Recommendation Report for Planning Permission for Works or Extension to a Dwelling

REF NO: BE/108/19/HH

LOCATION: Anderson Cottage
Shripney Road
Bognor Regis
PO22 9PA

PROPOSAL: Removal of existing conservatory, rear extension and alterations to roof to provide first floor accommodation

Drg No: 1544/19/P/03

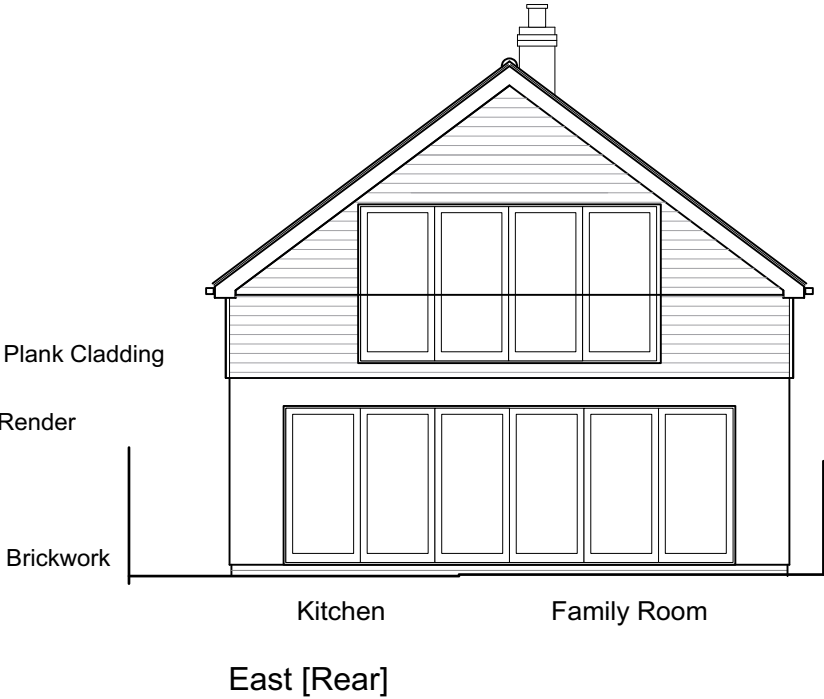
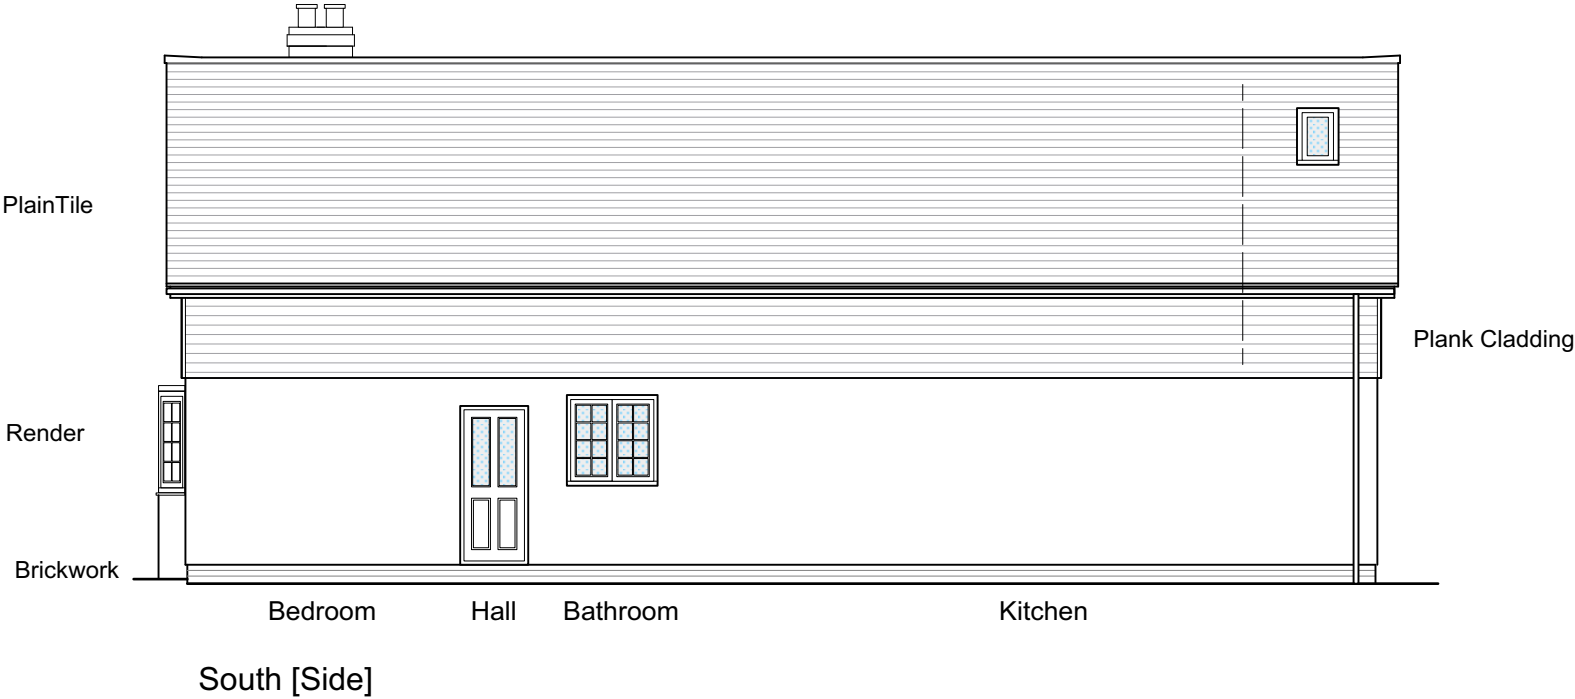
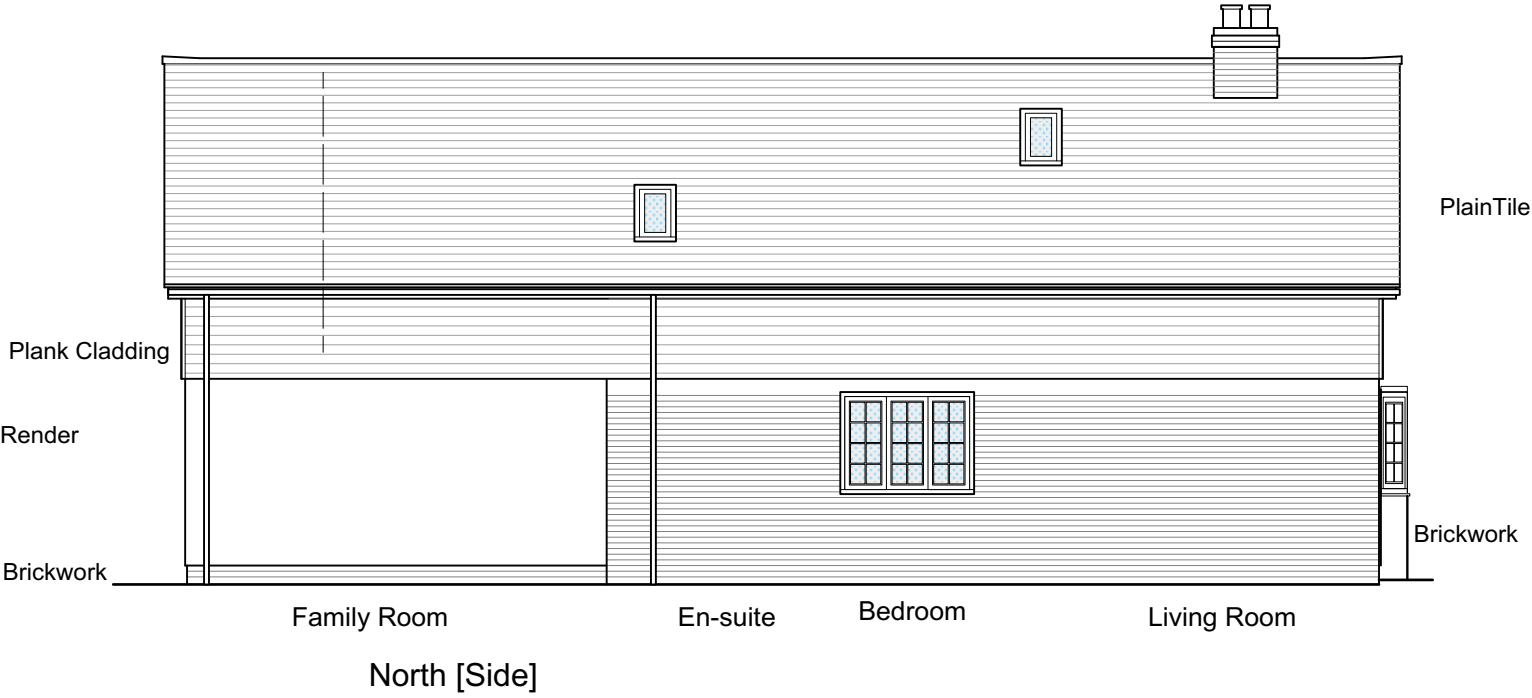
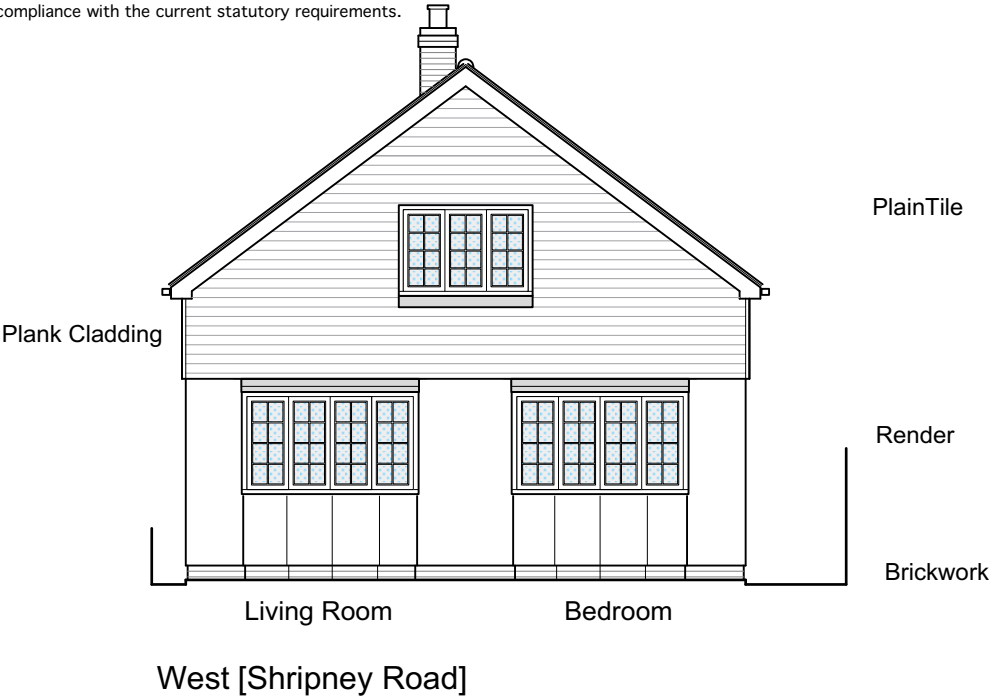
The proposal will be highly visible from the street scene. The development is not considered subservient to the host dwelling. This is a result of the scale of the changes proposed with a height increase of approximately 1.2m to the host dwelling. The proposal is however well integrated and sympathetic in appearance to the host dwelling.

The external materials will alter from render to include cladding at first floor level. As a result, the appearance will change however this is considered to improve the appearance. The surrounding properties are of a varied style and design and the alterations are not considered out of character with the area.

With approximately 12m remained to the front boundary of the site, the proposal does not appear unduly dominant.

The dwelling will also increase the ridge height by approximately 1.2m. However, due to the siting of the property, it is not considered to result in an overbearing or overshadowing impact upon surrounding properties. The building sits close to the northern elevation however this forms a driveway for access to the property at the rear of the host dwelling. The property to the south 'Nestledown', whilst a bungalow is of similar size to the host dwelling and with no windows at first floor, the alterations are not considered to result in adverse impacts.

There will be an additional window at first floor rear gable end. There is a property located to the rear of the dwelling however with around 20m to the rear boundary and further retained to the side of the neighbouring property, the proposal is again not considered to result in adverse overlooking.

Drg No: 1544/19/P/02

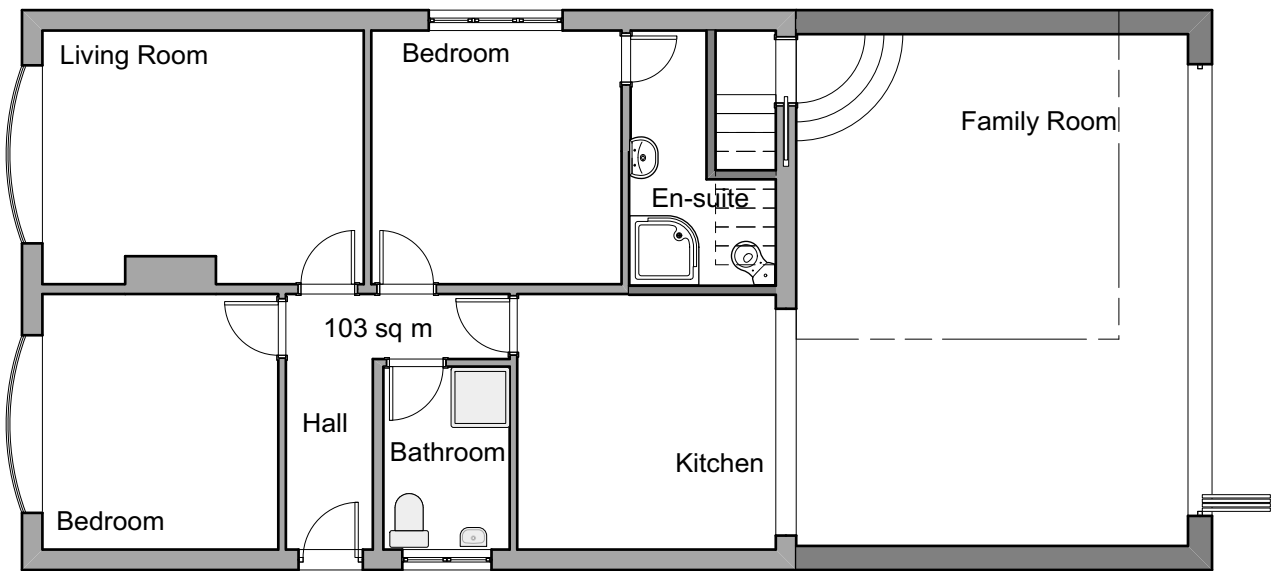
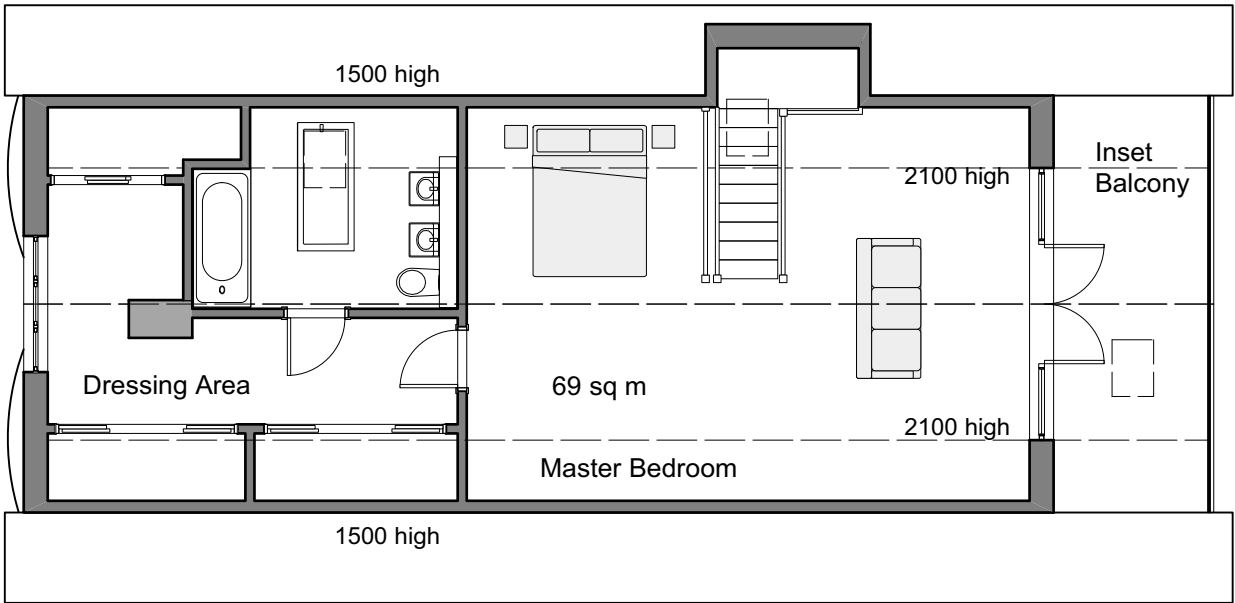
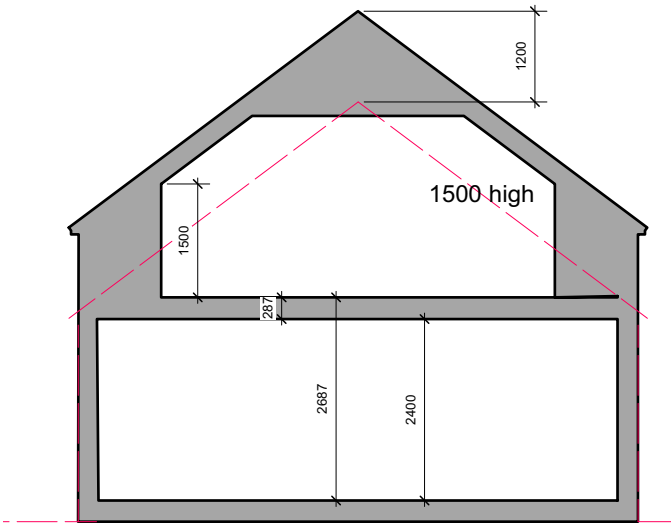
The dwelling will remove an existing rear conservatory and construct an extension increased in depth and height, following the ridge height of the host dwelling. The extension will have a depth of 5.5m from the original rear wall of the dwelling and this will extend the full width of the rear. This is around a 1.5m increase from the existing addition.
